CITY OF ALBUQUERQUE

Planning Department Transportation Development Services Section

February 10, 2014

Re: Certification Submittal for Certificate of Occupancy for
Rancho Del Cielo, 4801 Gibson Blvd SE
Architect's Stamp dated 2-03-14 (L19-D024)
Certification dated 2-03-14

TRAFFIC CIRCULATION LAYOUT

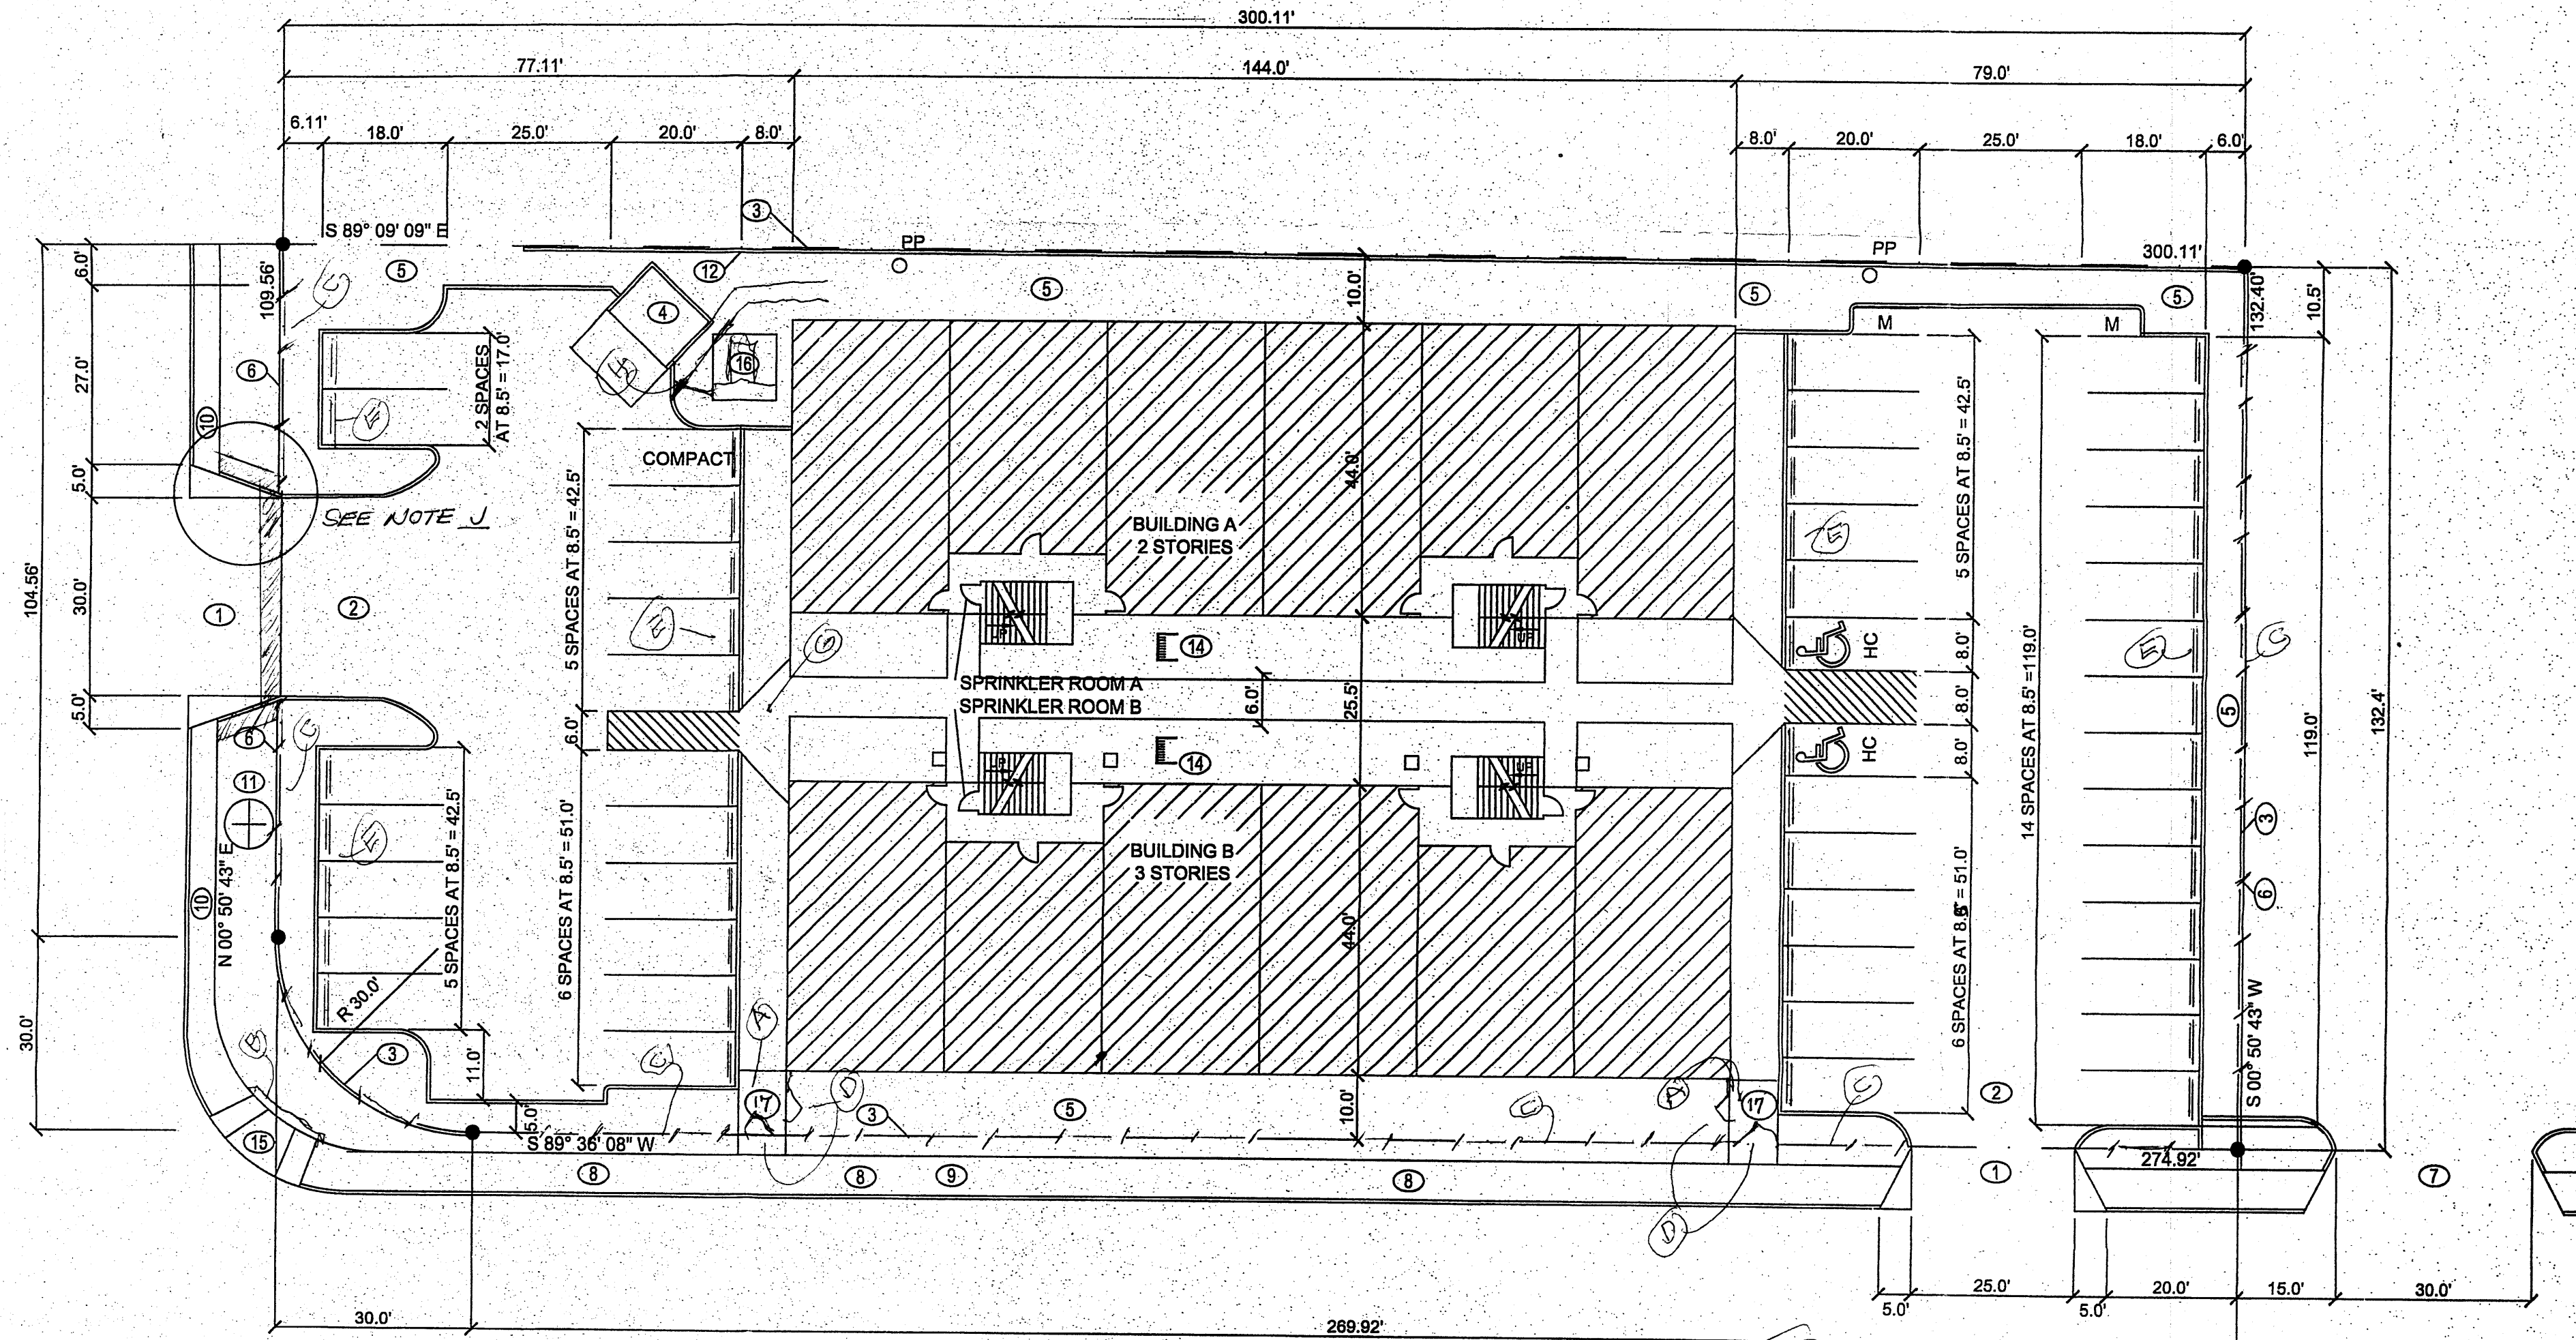
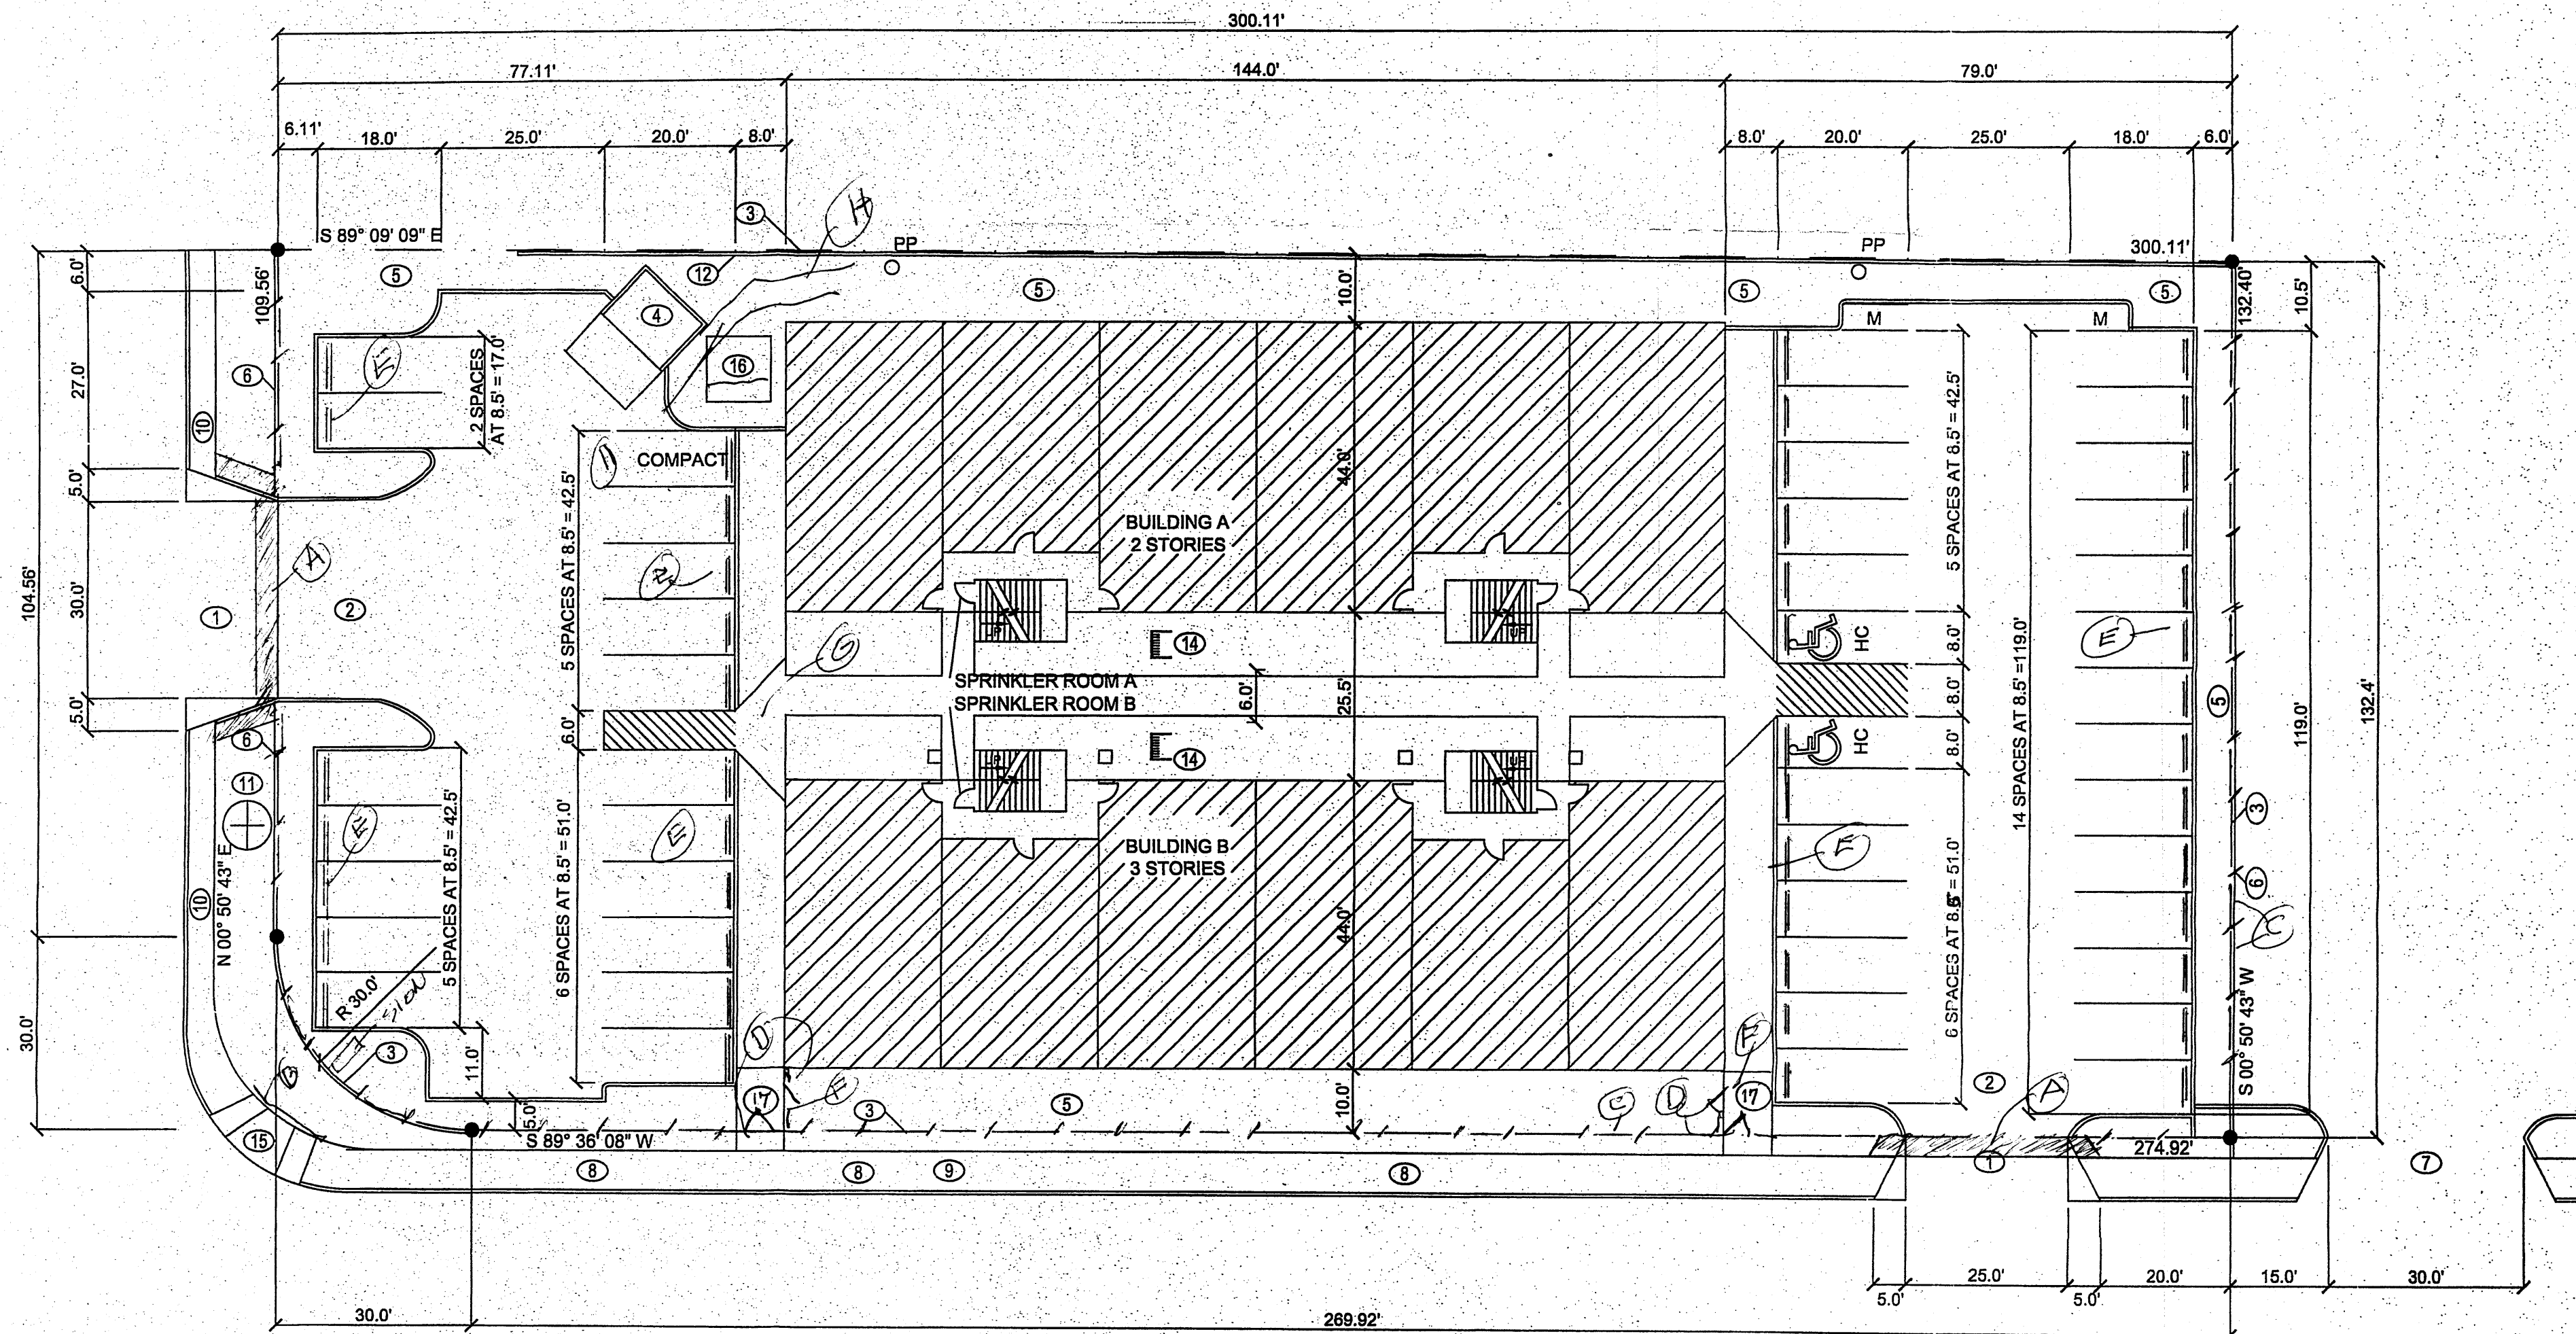
- The new driveways fronting Gibson Blvd and Jackson Street are not ADA accessible. City of Albuquerque (COA) standard drawing 2425 was referenced but not constructed for ADA accessibility. The correction to the new driveway fronting Jackson Street has introduced a tripping hazard at the ADA transition.
- Please redline all changes to site plan

The TCL (or DRB Site Plan) submitted for Final C.O. needs to be the exact copy of the approved TCL in the plan set approved for building permit. This will be the latest edition, which may have redlined comments, initialed and dated by the designer-of-record.
